ENG-CDR19004-R4-FDR-Redlines .pdf Markup Summary

MERIDIAN ROAD DRAINAGE PLAN

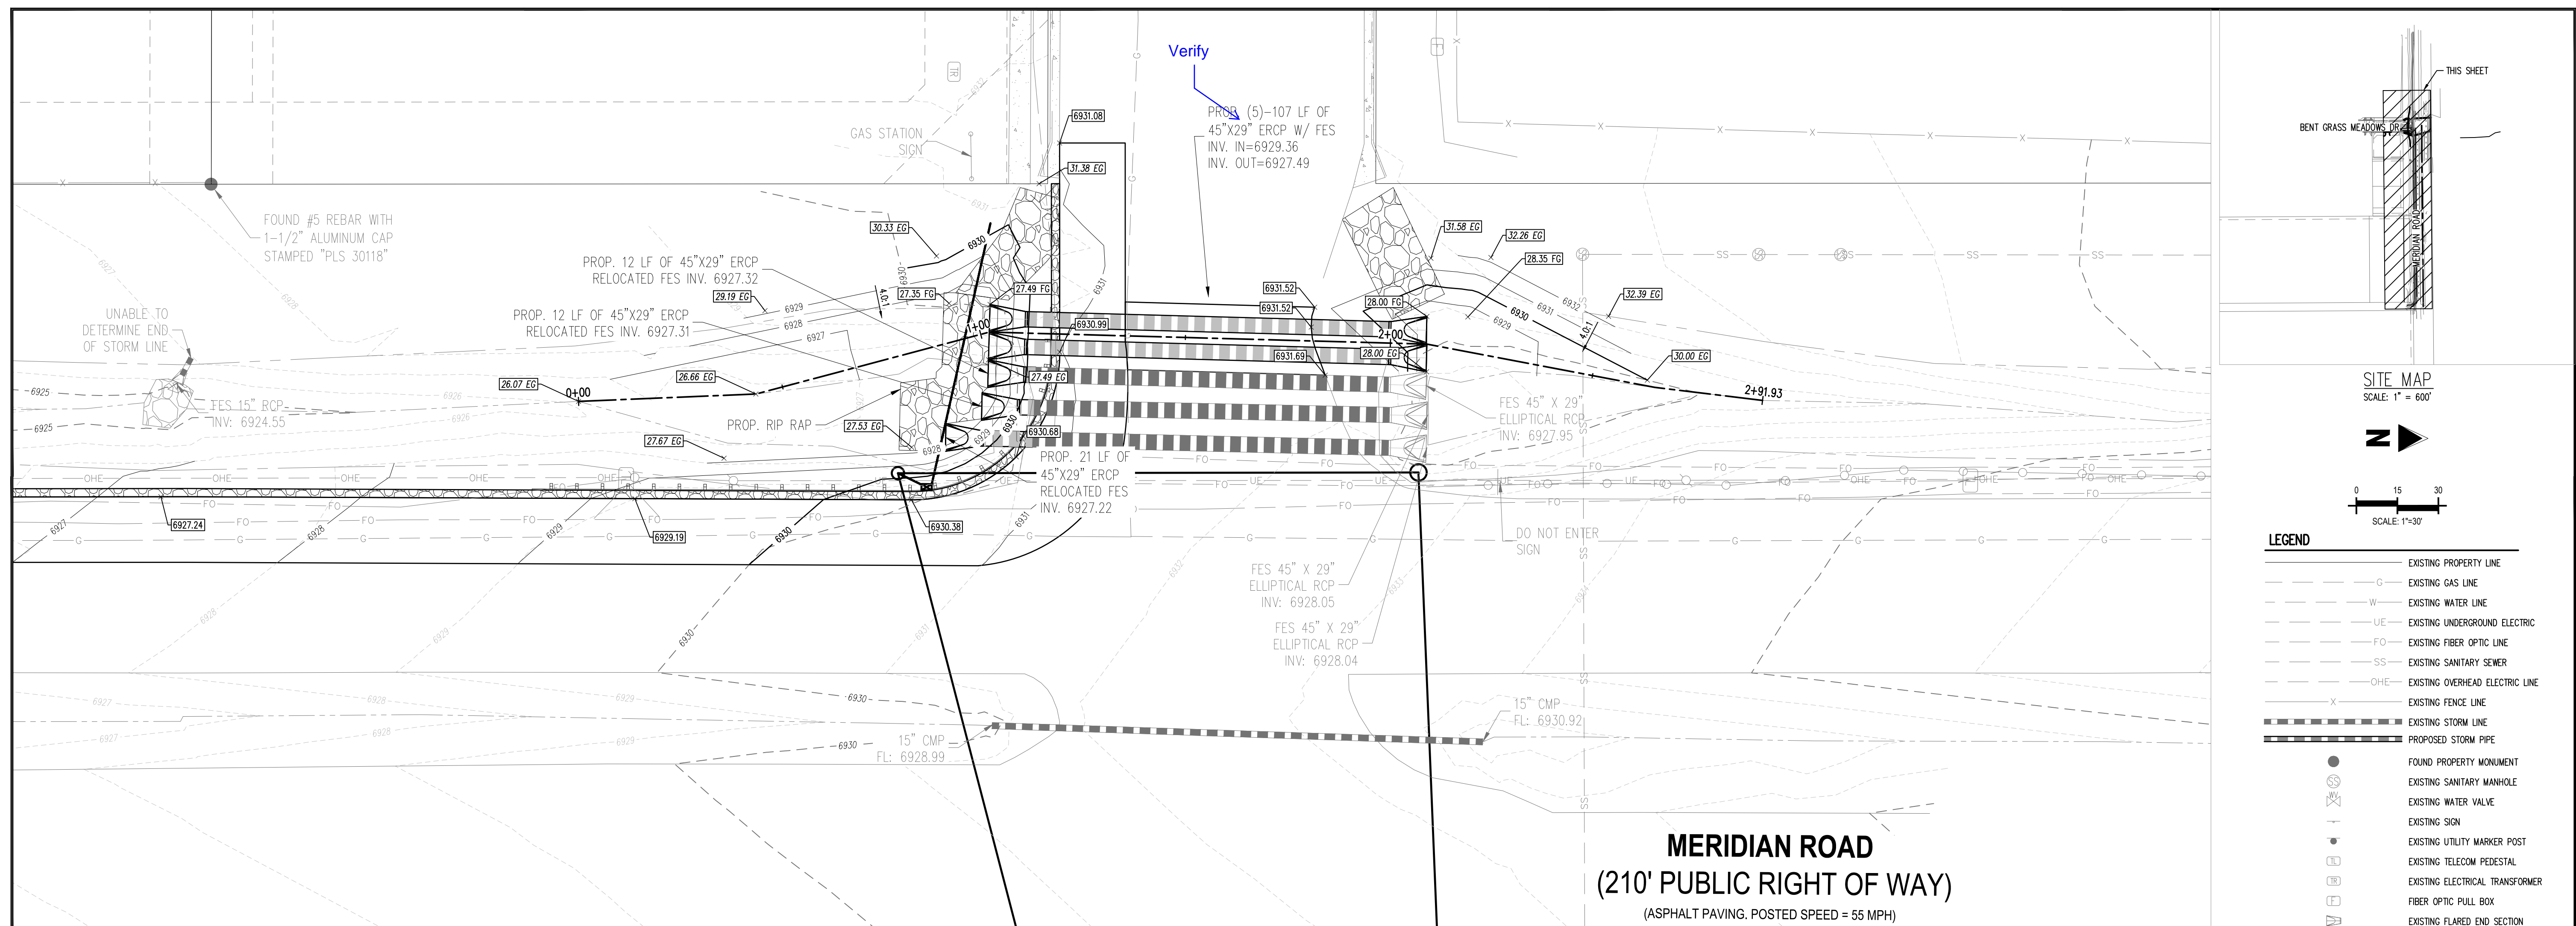
Are these flows actually conveyed to the north flowline? Address street capacity calculations.

Address the Owl Place culvert and downstream conditions and necessary easements for increased flow.

Label the flows from the west
